SOUTH HOLLAND DISTRICT COUNCIL

Purpose: To consider Planning Application H09-0307-22

Description: Residential Development - Erection of Dwelling

Location: Chancery Lane Holbeach Spalding

Scale	1:50 1:100 1:200 1:1250 @ A1	Drawing No.	2113-01-D
Date:	MAR. 22	Drawn:	J.C.

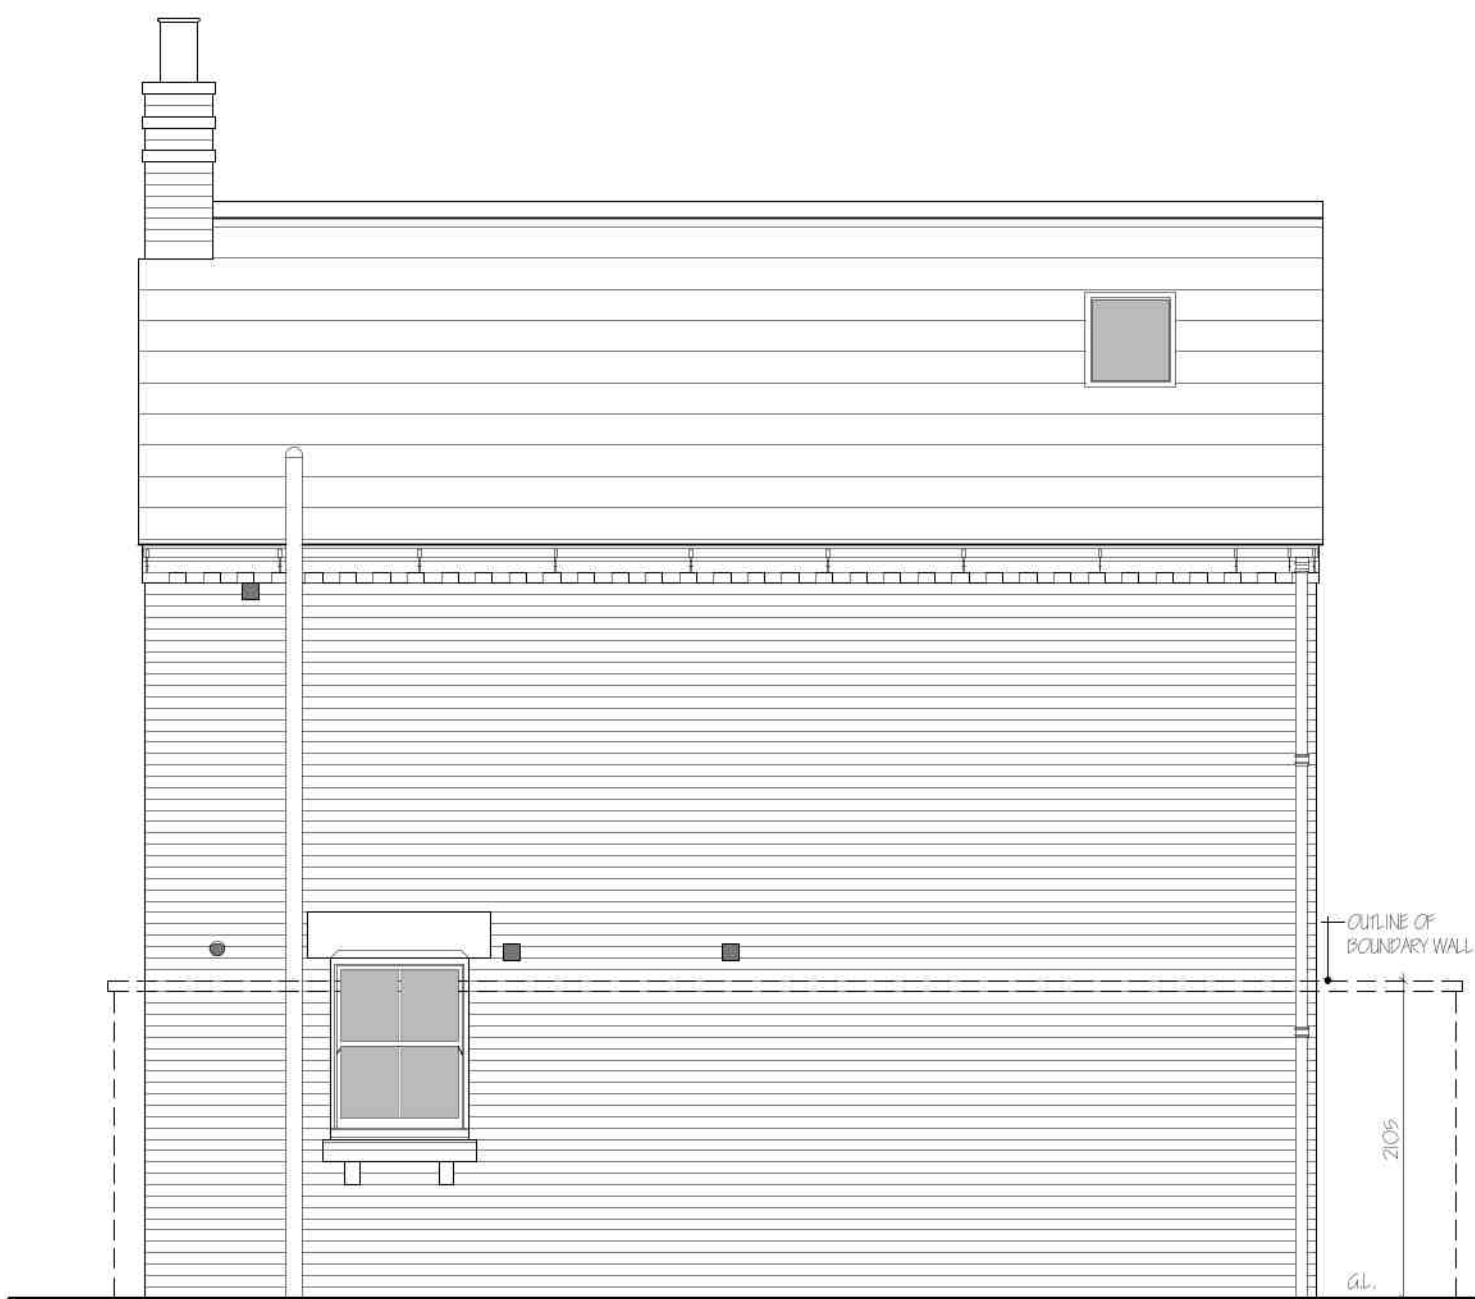
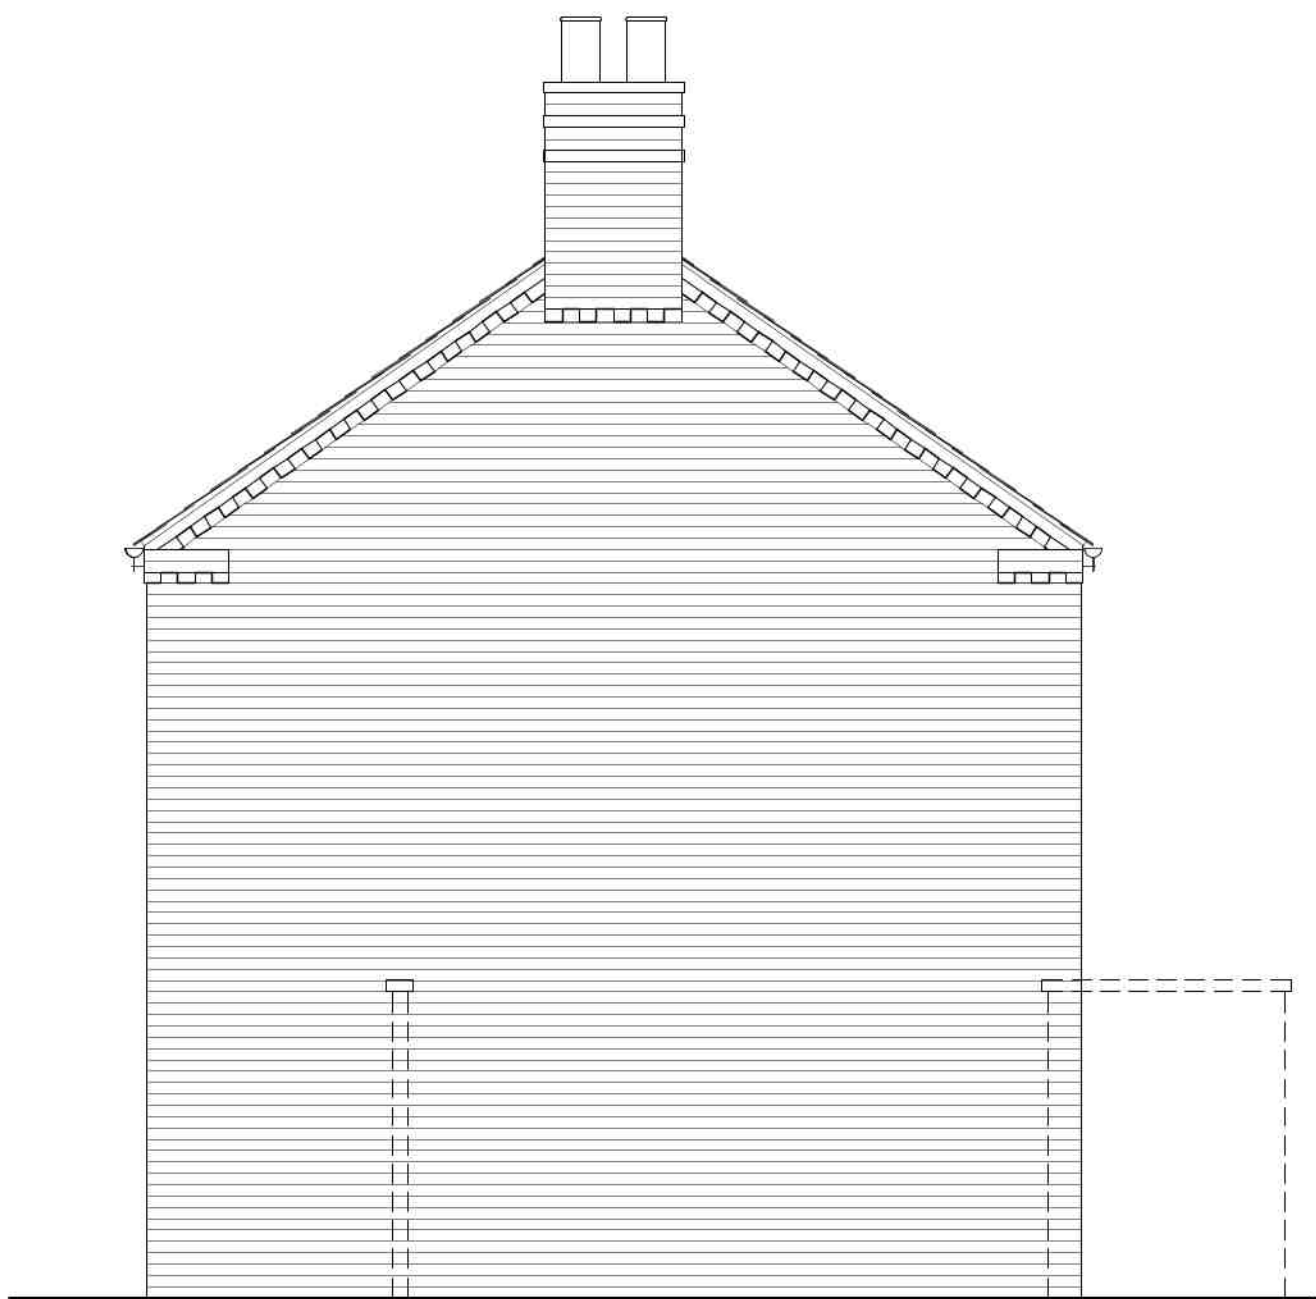
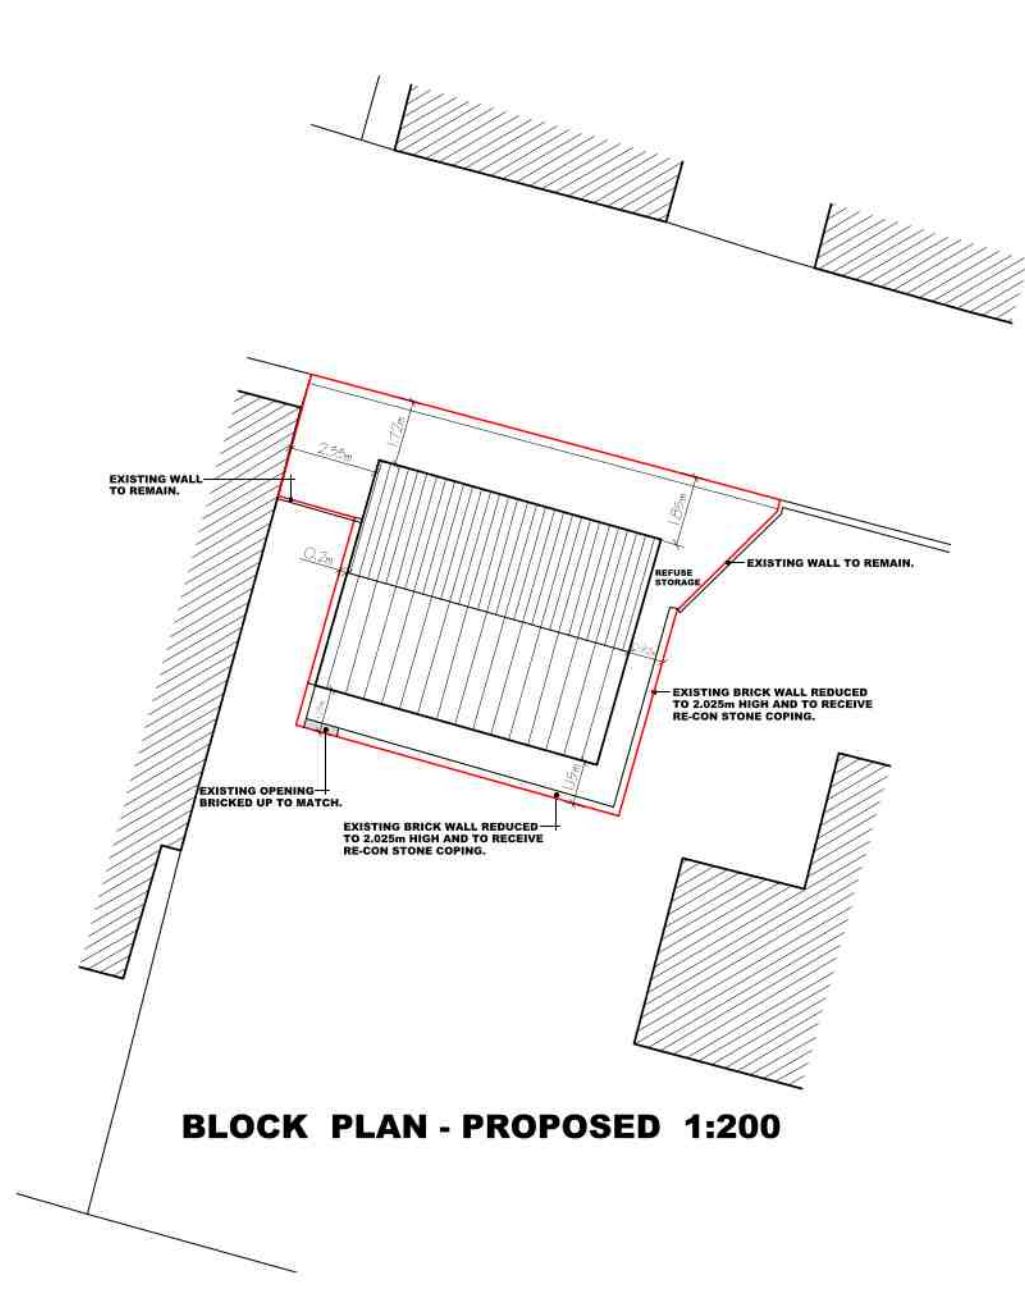
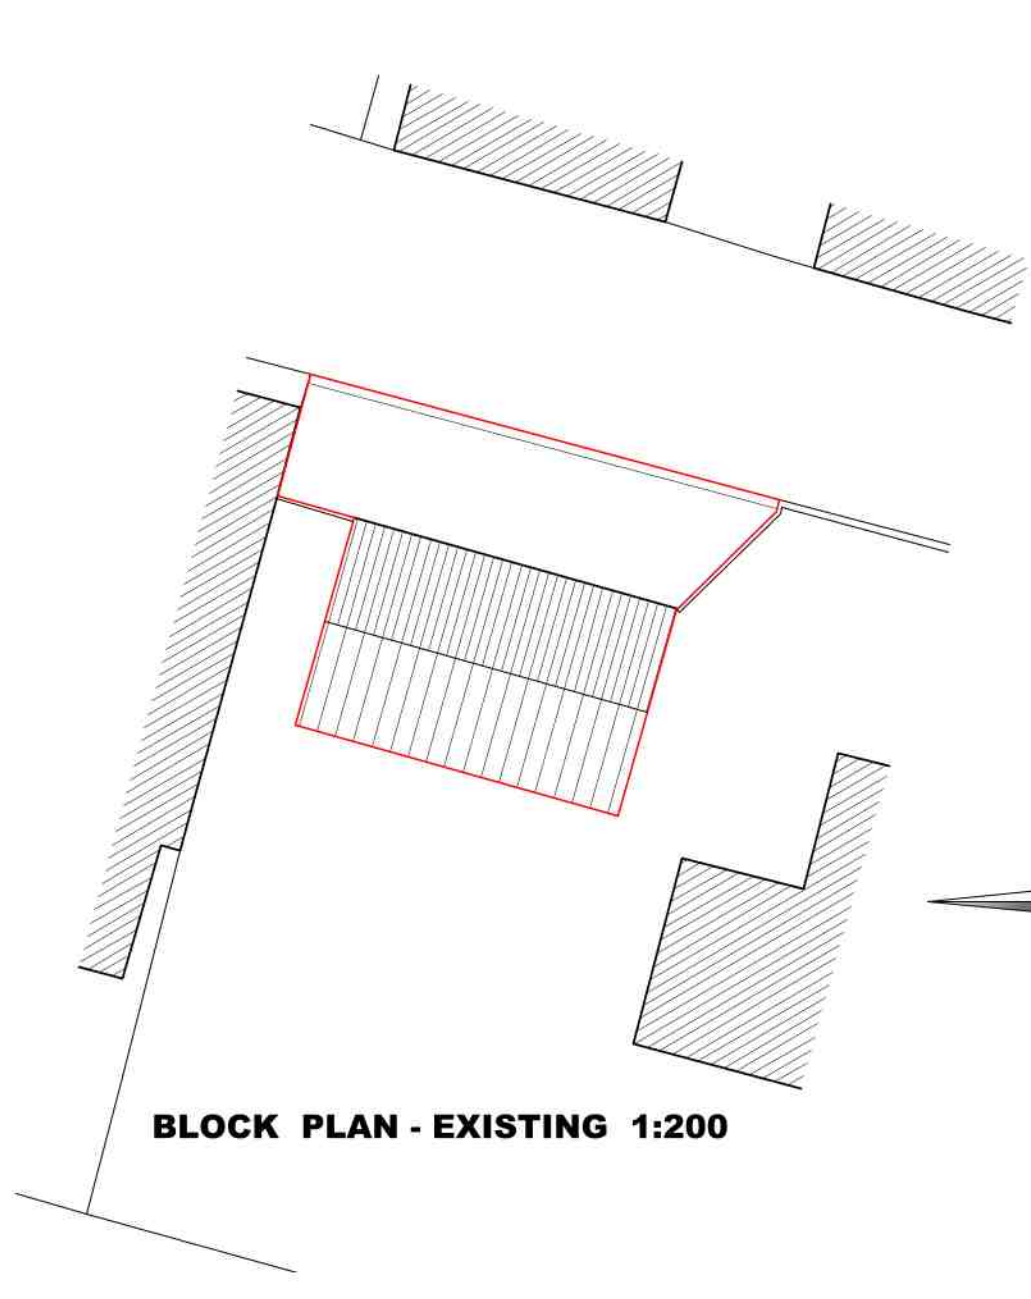
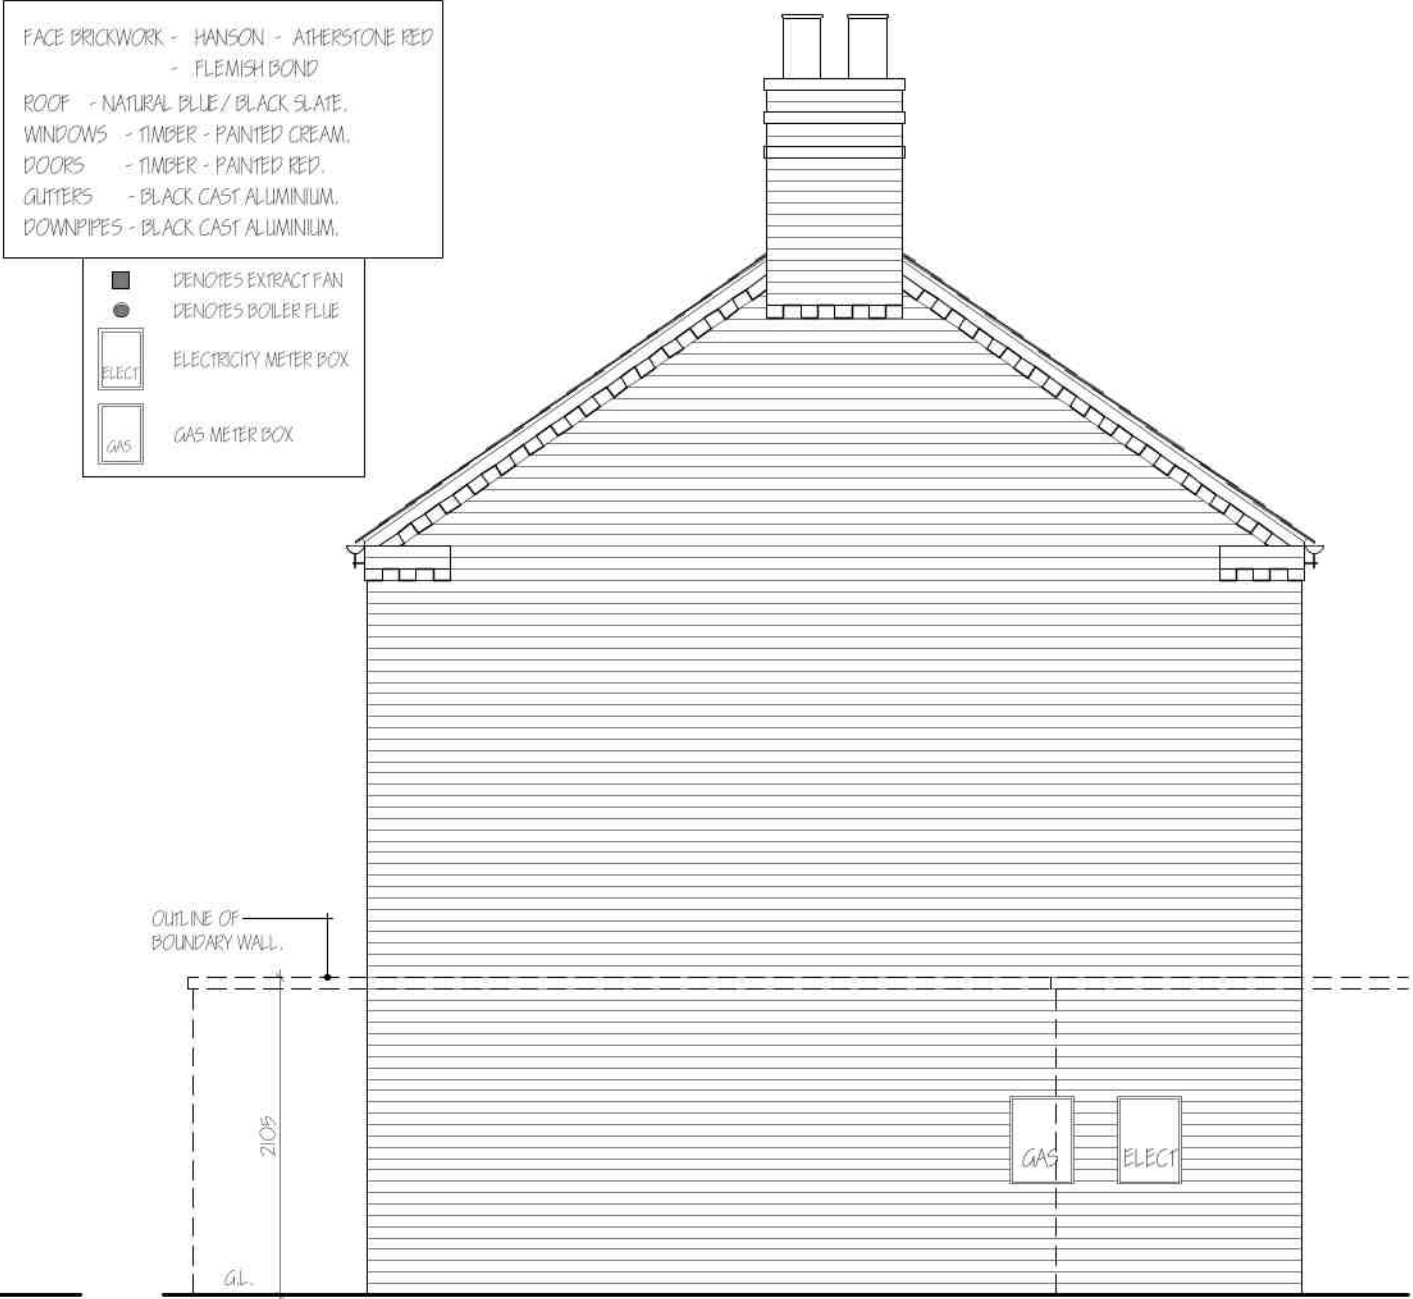
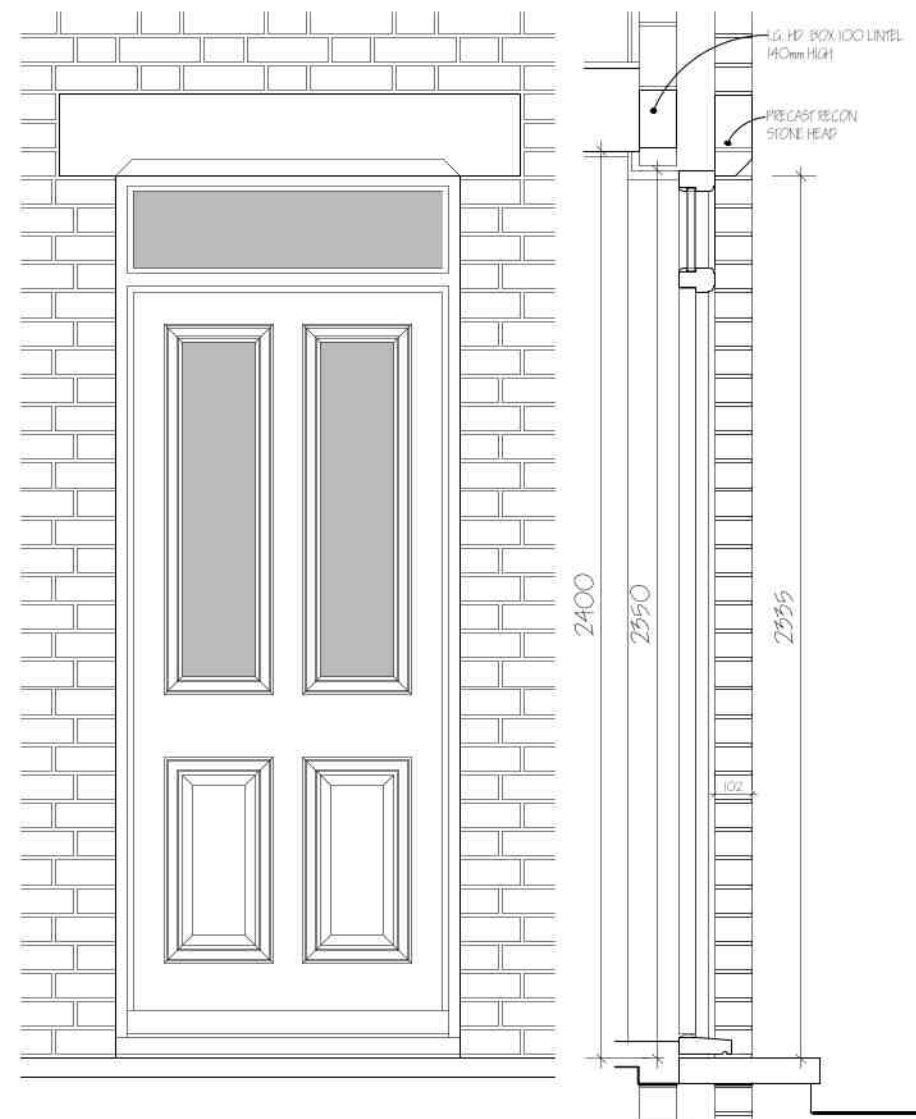
Having spoken again with neighbouring residents, who are understandably upset about the application due to the privacy issue - in my view the easiest solution to this application and to minimise the biggest issue for nearby properties would be to remove the kitchen window in the south wall therefore removing the main privacy issues.

If this unfortunately is not an option, then at very least I would suggest that a condition should specify that the glass should be frosted at the top part of the window which would go some way to alleviate the privacy concerns. I would welcome the first option to be considered very strongly please and the 2nd suggestion as a last resort.

- Overlooking/loss of privacy to neighbouring properties. Overlook into neighbouring bedrooms. Top of rear kitchen window should be frosted glass
- Overshadowing/blockage of light

- Double garage door in existing rear wall should be bricked up to match
- Why is fencing proposed along eastern boundary as opposed to retention of the existing wall

- 7.18 The dwelling would have no openings on its side (east and west) elevations. The rear (south) elevation has a high level rooflight associated with a bedroom. A kitchen window is located at the rear at ground floor level. Given that finished floor levels would be set at 300mm and

average male adult eye level is approximately 1.65 metres boundary screening should be in the region of 2 metres. It is noted that the property has a ground floor lounge and first floor bedroom windows facing north towards no 16 Chancery Lane, which is situated directly opposite. However, the separation distance would be approximately 8 metres which is typical of an urban terraced street such as this. The site is close to the town centre where amenity levels are generally lower and ambient noise levels are higher than average due to traffic noise and general activity. It is considered that the amenity of neighbouring residents would not be materially harmed in terms of overlooking, lack of privacy, overshadowing, blockage of sunlight or noise and disturbance.

8. The scheme of boundary screening/treatment, including bricking up of the existing opening within the rear wall, shall be fully implemented in accordance with the approved details prior to occupation of the dwelling and shall thereafter be so maintained.
